DECISION DELEGATED TO HEAD OF PLANNING

Application No: H14-0635-24 **Applicant:** Stagecoach Services Ltd

Proposal: Construction of a new concrete slab for a fuel tank, storage containers and walk around bus wash, new office cabins, cycle shed, car, mini bus, double decker parking spaces and ancillary works - Retrospective

Location: Pinchbeck Industrial Estate Wardentree Park Spalding

PROPOSED SITE LAYOUT PLAN - 1:200

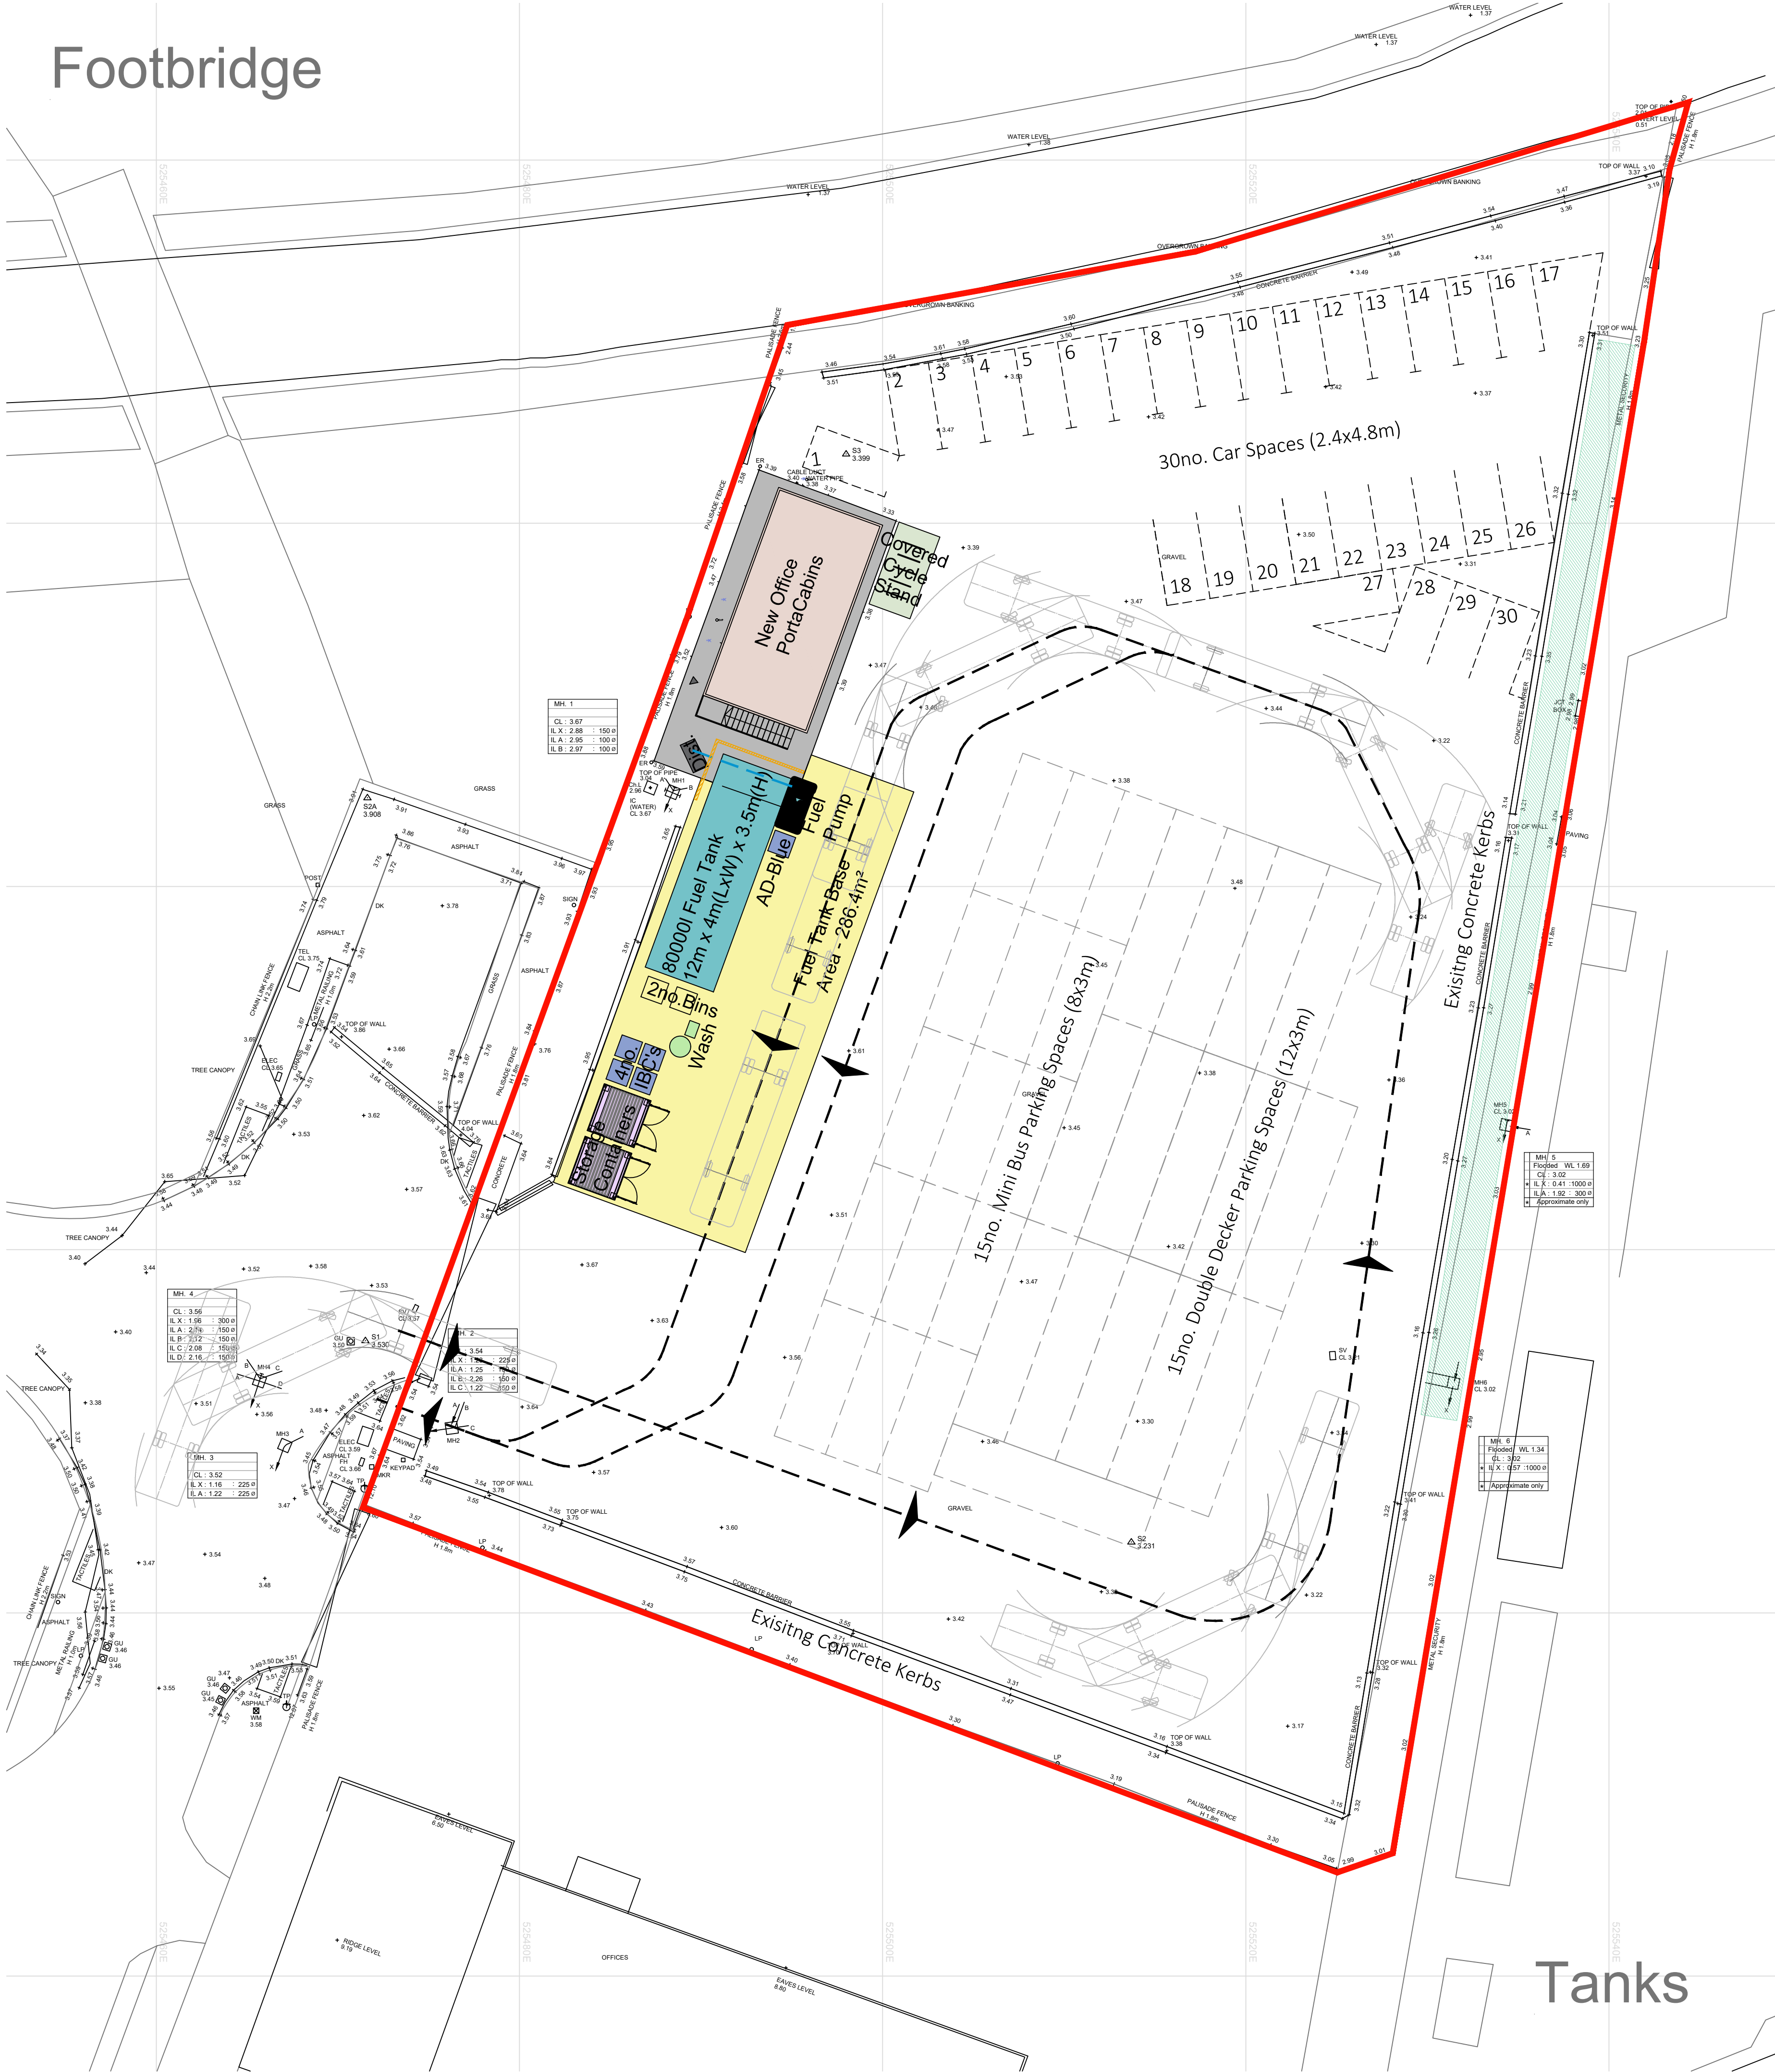
I have recently attended site and there has been a bicycle shelter erected directly in the path of our access route to undertake statutory maintenance. This is a contravention of the Board's byelaws. The bicycle shelter must be relocated elsewhere on site outside of the Board's nine metre byelaw distance strip.

It was also noted on site that a portacabin has been placed within the Board's nine metre access strip on top of an existing concrete slab without the prior consent of the Board having been sought. The Board will not be granting permission for the portacabin's placement, and if the Board ever require the portacabin to be moved/relocated for operational purposes then this will be done so at the applicants' expense subject to receiving notice from the Board.

2. I commend the creation of a 2m x 60 m shrub belt along the east side of the site, however, the site plan is not clear whether this belt is encroaching on the existing habitat associated with the drain? There may be a problem with too much overshadowing of the drain, and therefore, we need an estimation of how far the shrub/scrub habitat will be from the top of the drain bank. In addition, in relation to point 1, this margin of shrub could be extended to improve the post-development unit provision required to offset the inclusion of ruderal/ephemeral habitat in the baseline calculation.

3. There is another concern in relation to the drain. If any development (including additional asphaltting or 2m+ high fencing) occurs within 10 m of the top of the drain, then this would be considered to impact the watercourse, and 10% net gain will also have to be achieved in watercourse units. This may be possible with the appropriate ditch management, but we would also require a watercourse assessment, and the watercourse sections of the metric to be completed.

"I am happy using the attached plan that Rob has kindly forwarded directly to me that the Board are satisfied that all obstructions are now no closer than the Board's 9m byelaw distance - except for the cars that as per the emails Rob has today forwarded you the Board are again satisfied that by providing 48 hours' notice we will have a clear access strip for undertaking our statutory duties.

The IDB initially raised concerns regarding the proximity of structures to the relevant asset. Revised plans have relocated the bicycle shelter outside of the nine metre byelaw distance; thereby alleviating the concerns of the Board.
